Heather Fox IP FCC2DAFFA

Summary

Volume 9.0 Other post- Submission Documents

Applicants Response to Deadline 3 Submissions

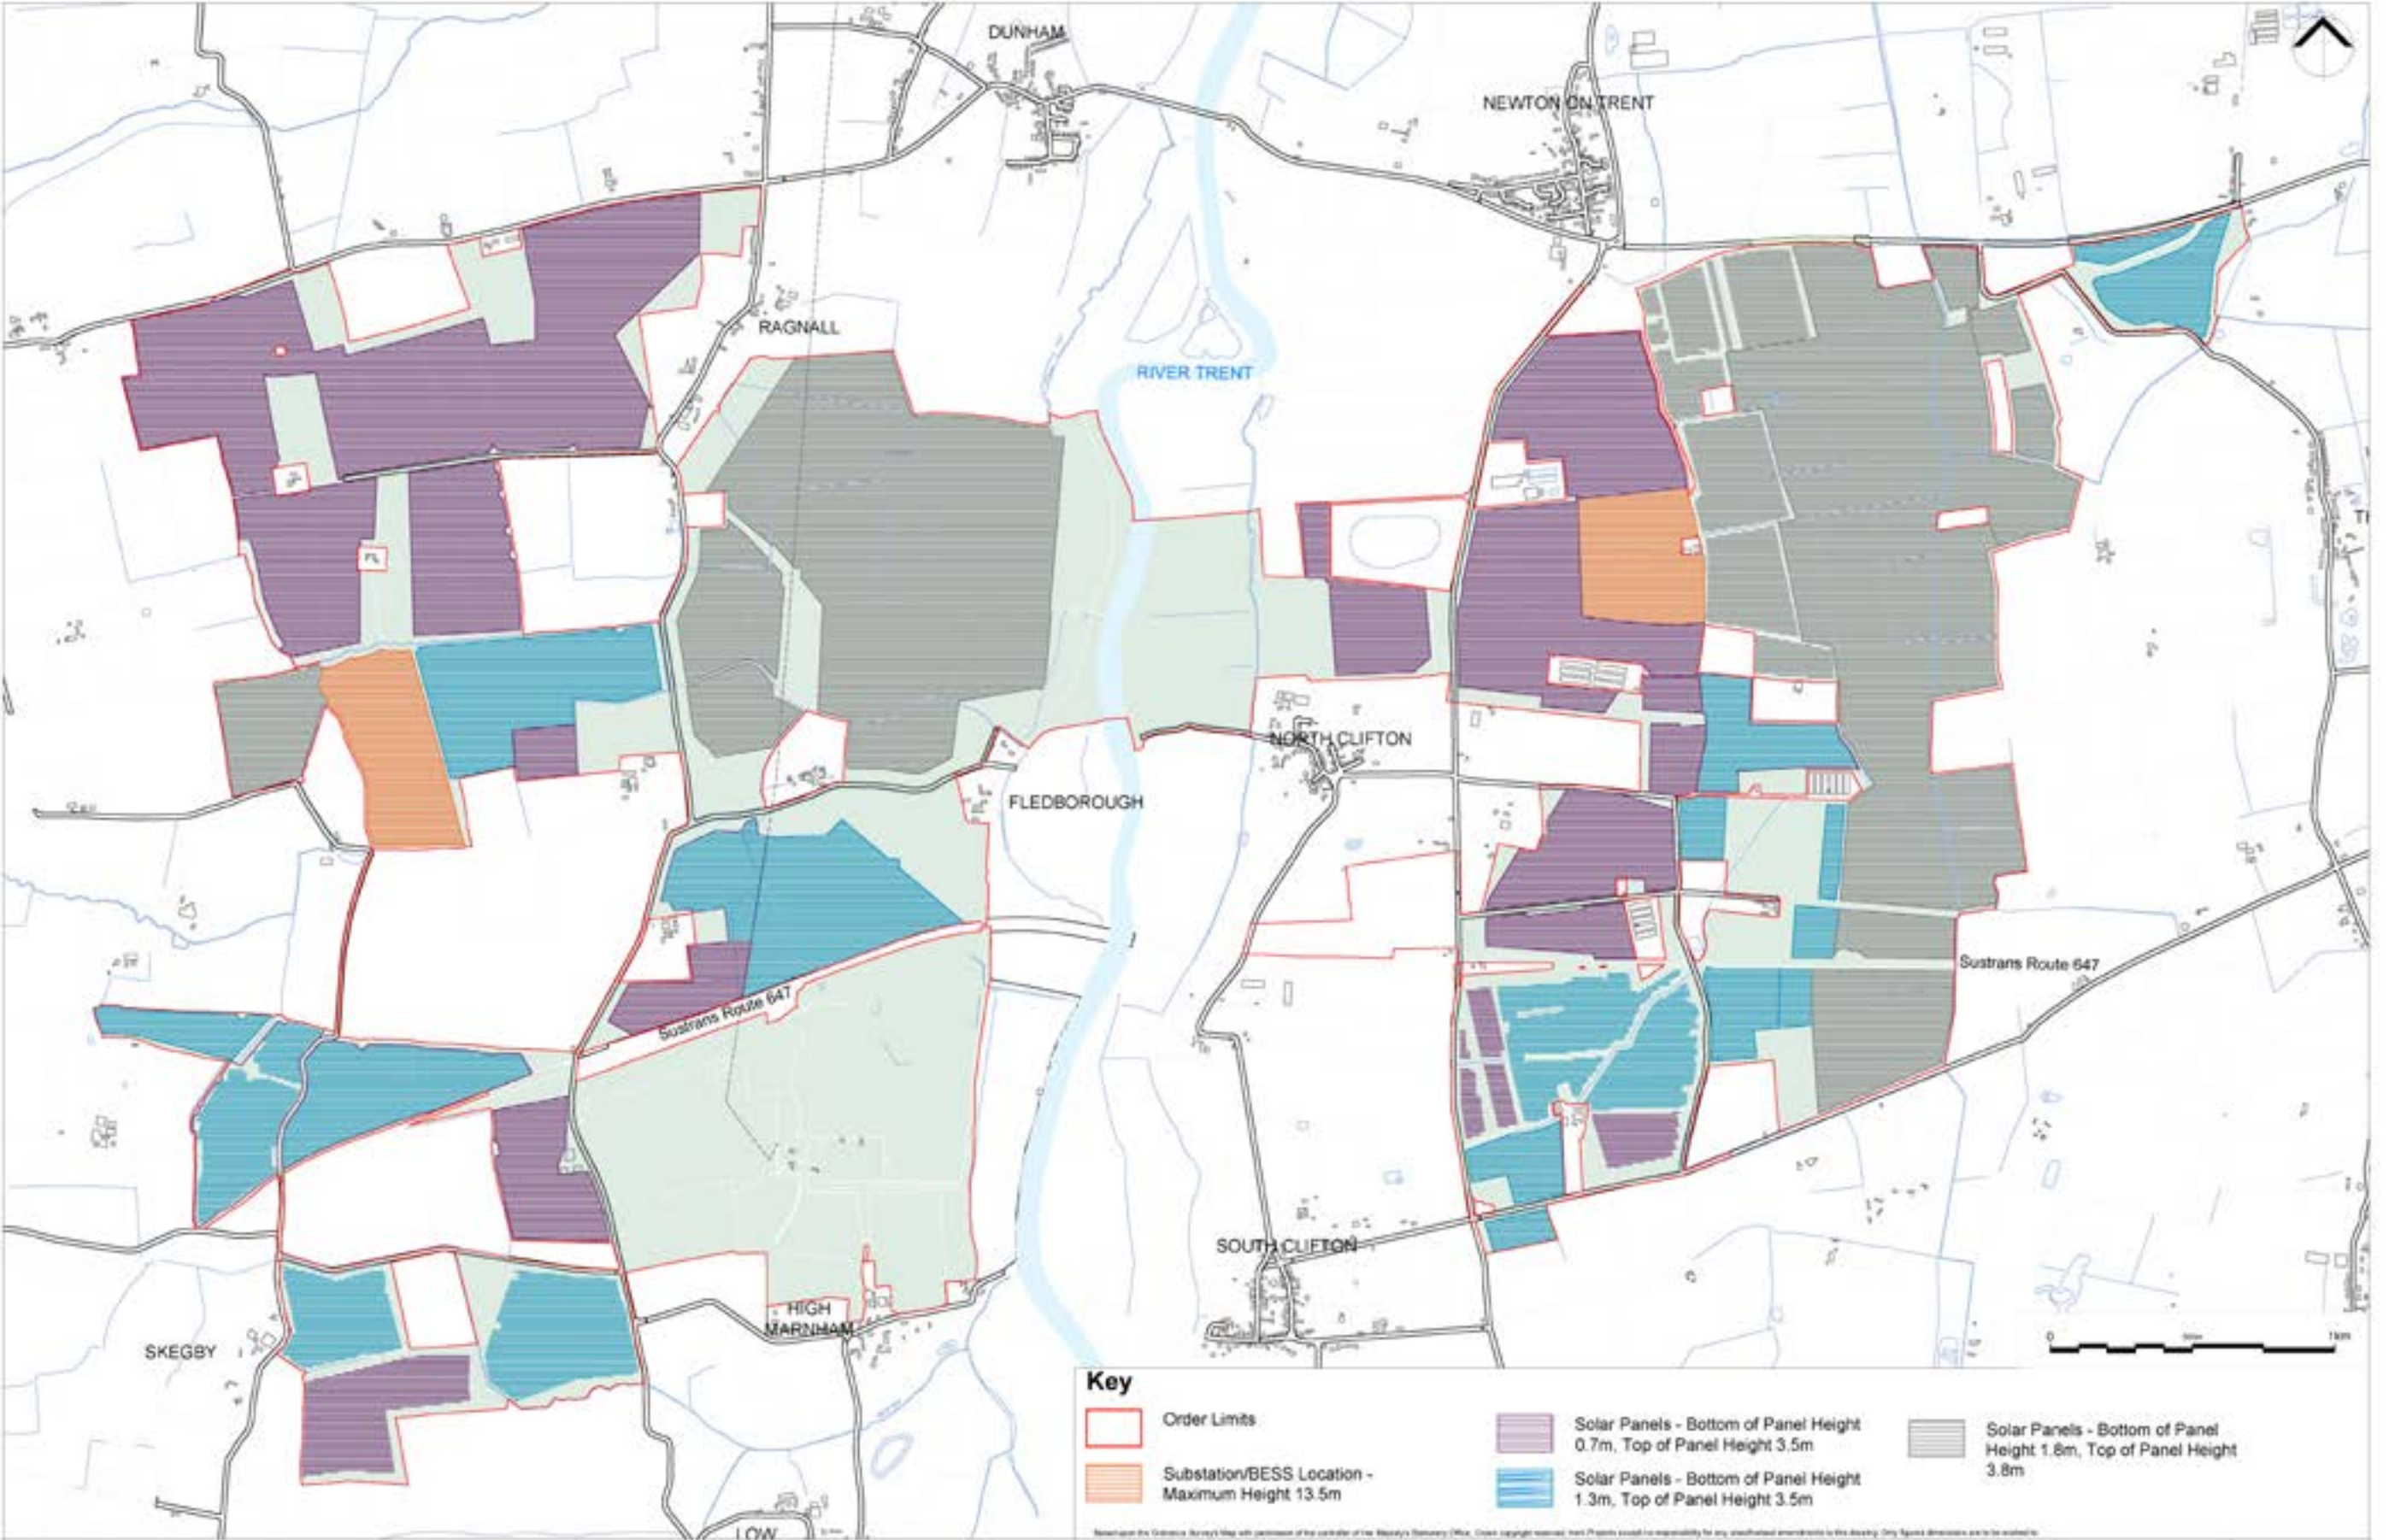
Why are the inverters being given the 300mm freeboard not 600mm, generally assigned to sensitive electrical equipment, that would make them safe for their lifetime, part of EN policy and especially as they are substantially in flood zone 3? The EA were still questioning the freeboard allowance of 600mms in the April 2025 Consultation Meeting, despite the applicant inferring at ISH3 that the 600mms, having been asked for “early on “had been dismissed. It evidently had not been. The EA surrendering the more robust 600mms freeboard before full knowledge of the large number of inverters, (sensitive electrical equipment, with considerable consequences should they flood) in flood zone 3 was surprising to say the least. A consequence of this premature lowering also meant many panels would be submerged. Why did the EA lower the freeboard allowance, thus removing the safety element and an undisputed non subjective amount, in favour of the subjective, disputable 5mm number?
